**CITY OF ALBUQUERQUE
PLANNING DEPARTMENT
April 9, 2008
DRB Comments**

PROJECT # 1007201

APPLICATION # 08-70162

RE: Lots 8, Block 2, Los Hermanos Addition

Plat of  
**Lots 8-A and 8-B**  
**Los Hermanos Addition**  
 Albuquerque, Bernalillo County, New Mexico  
 April 2008

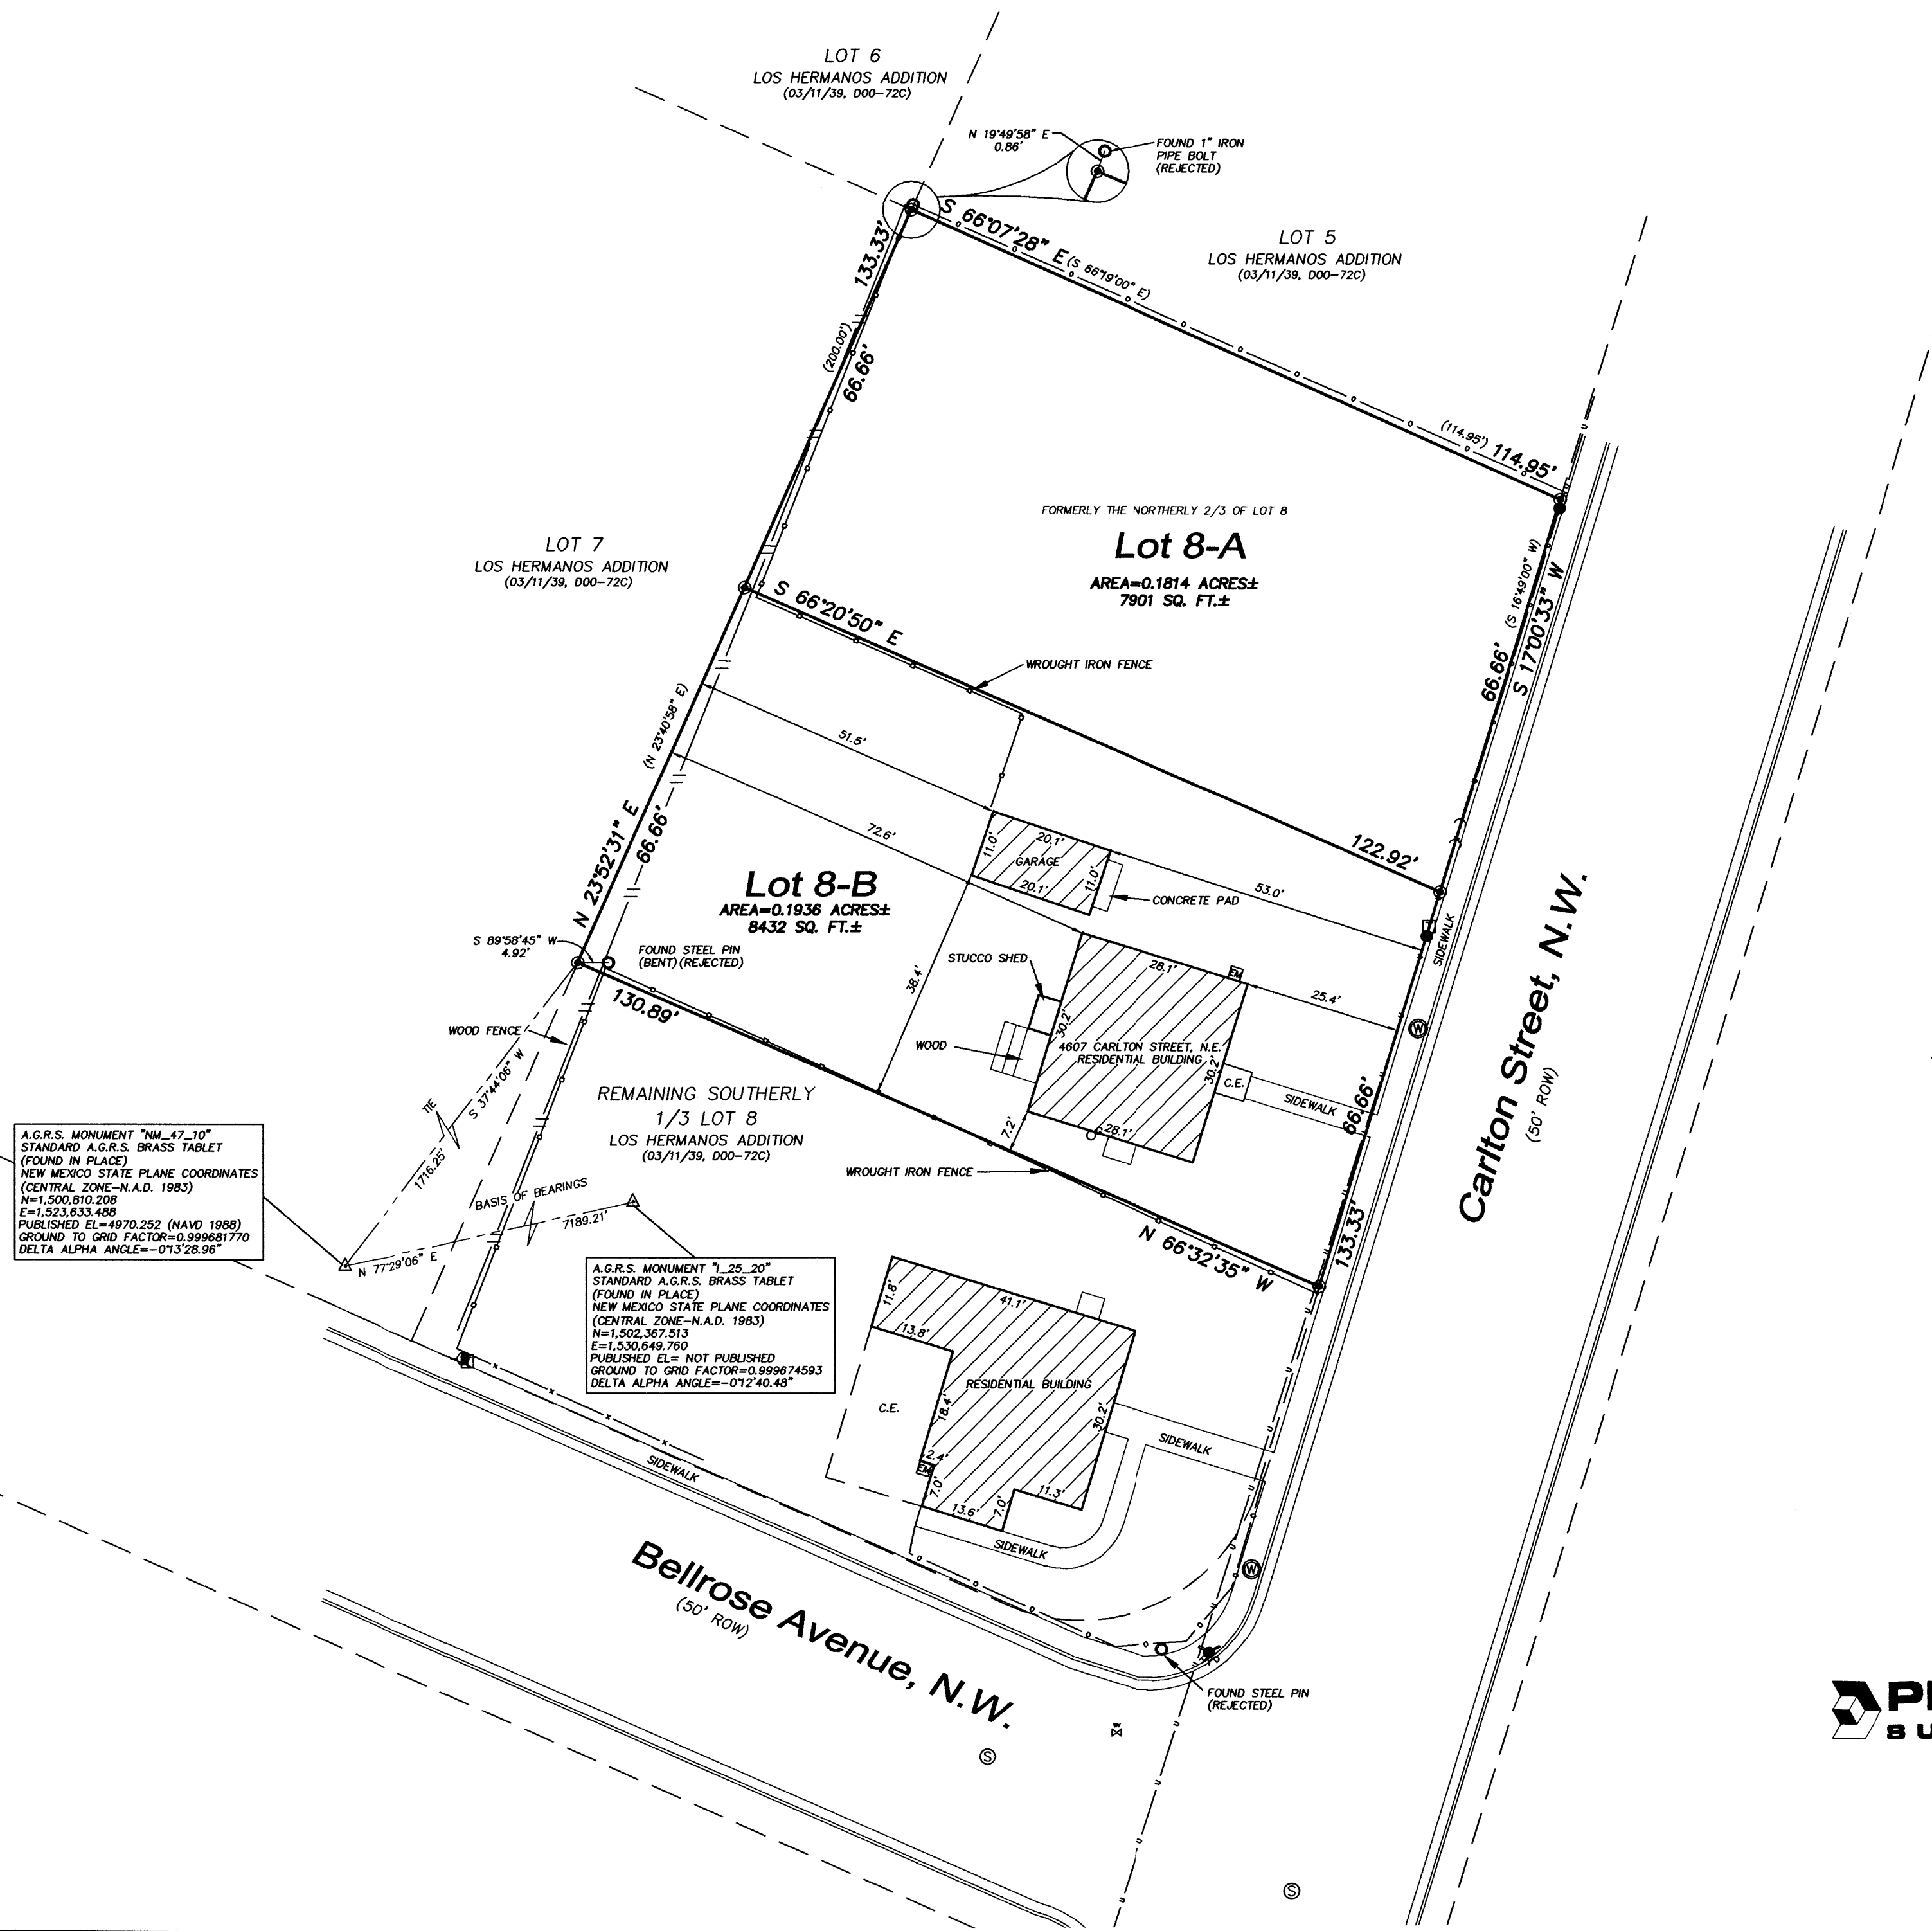
For future reference, please do not identify the property's zoning (Note 1) on the plat. Also, please revise solar note to be specific to this type of request, i.e. use the words "THIS PLAT" and not "REQUESTED FINAL ACTION" and do not use the words "OR SITE DEVELOPMENT PLAN FOR SUBDIVISION" at the end of the note.
